Ref: 6/2022/0529/HOUSE
Date: 20/04/2022

HISTORIC BUILDINGS AND CONSERVATION ADVICE

RE: 159 Parkway, Welwyn Garden City, AL8 6JA

The application is for the construction of two rear dormers to facilitate the conversion of the loft to habitable space.

7 Proposed Rear Elevation
1 : 100

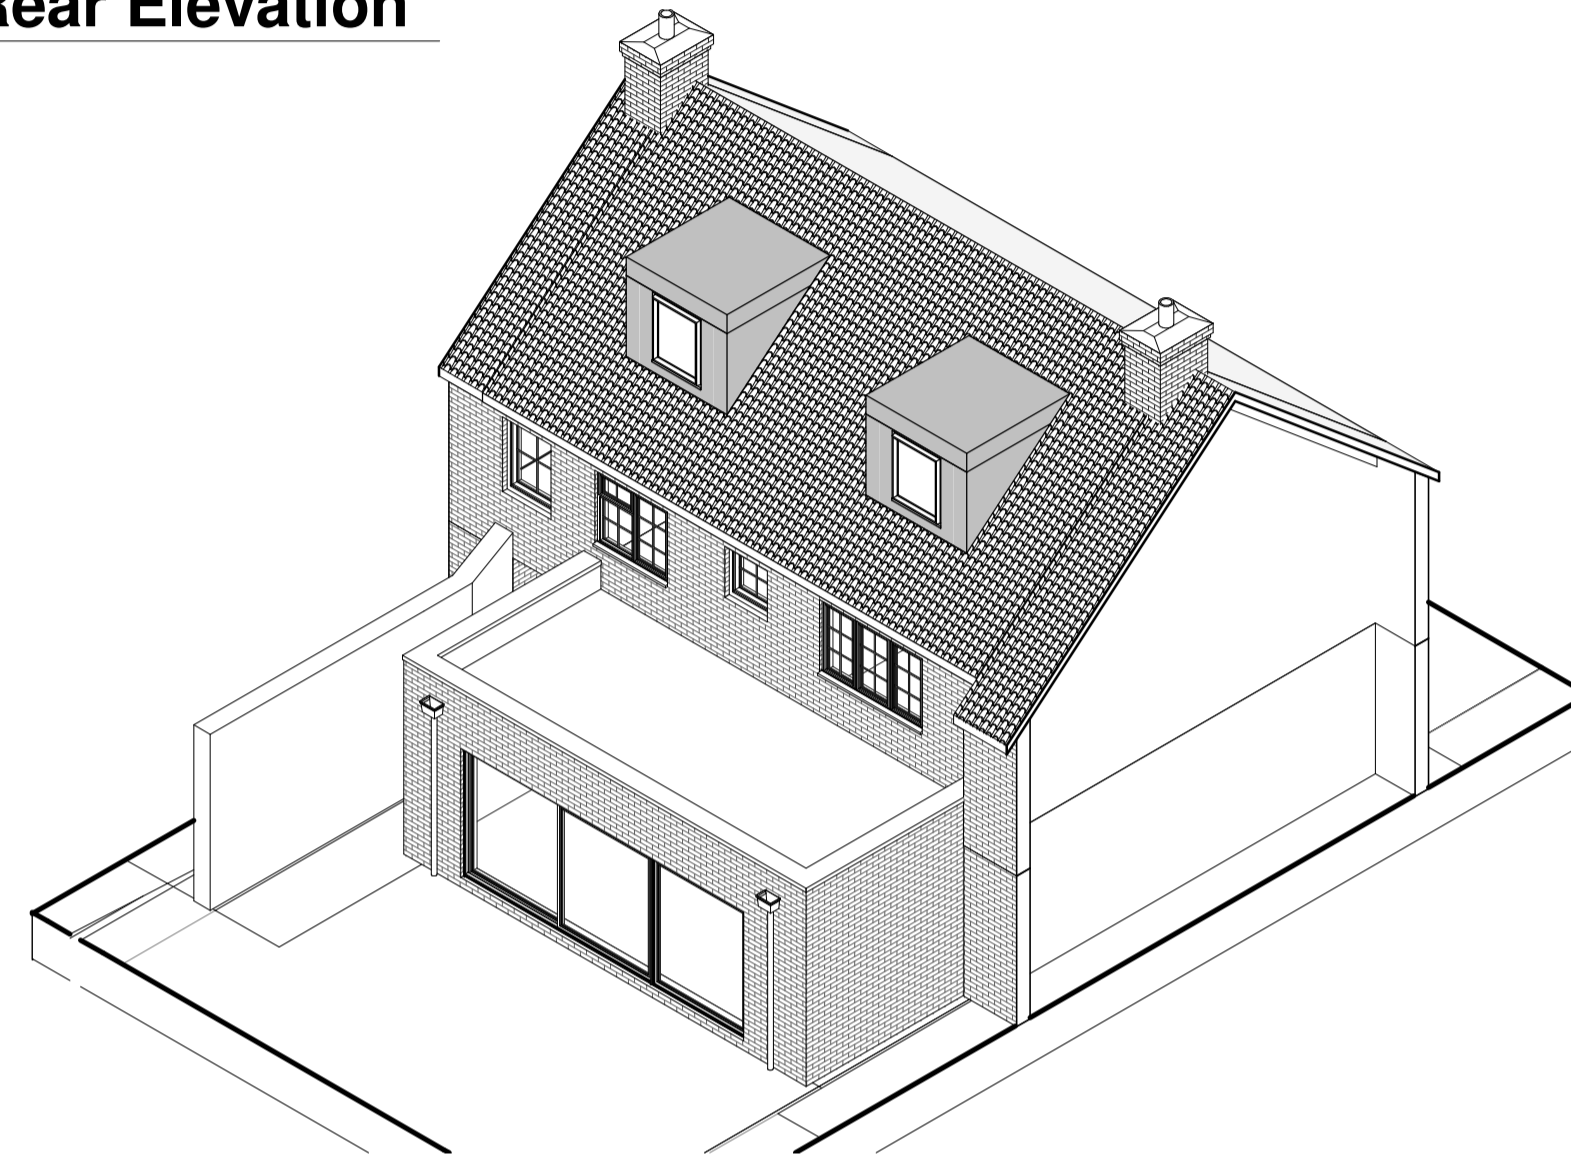
An objection was raised previously due to the proposed rooflights and dormers detracting from the uniformity and largely uninterrupted appearance of the roofscape of the terrace. Whilst the rooflights have now been omitted and the design of the dormers amended to incorporate a flat roof rather than a pitched roof, this concern still remains. The impact on the streetscene of Parkway is limited but it appears that the dormers will be visible in glimpsed views between buildings on Rooks Hill and Stanborough Close and, as noted previously, a lack of visibility from public areas does not equate to a lack of harm as the rears of buildings are seen from neighbouring gardens which are also within the Conservation Area. Dormers would be an incongruous feature to the terrace.

Whilst improved through the removal of the previously proposed rooflights, the proposed dormers are still considered to cause 'less than substantial' harm to the significance of the Conservation Area and paragraph 202 of the NPPF should be applied. Consideration should also be given to paragraph 199 which affords great weight to the conservation of heritage assets and Section 72 of the Planning (Listed Buildings and Conservation Areas) Act 1990 which states that special attention shall be paid to the desirability of preserving or enhancing the character or appearance of Conservation Areas.

There may be scope for rear rooflights as these would be less visually intrusive.
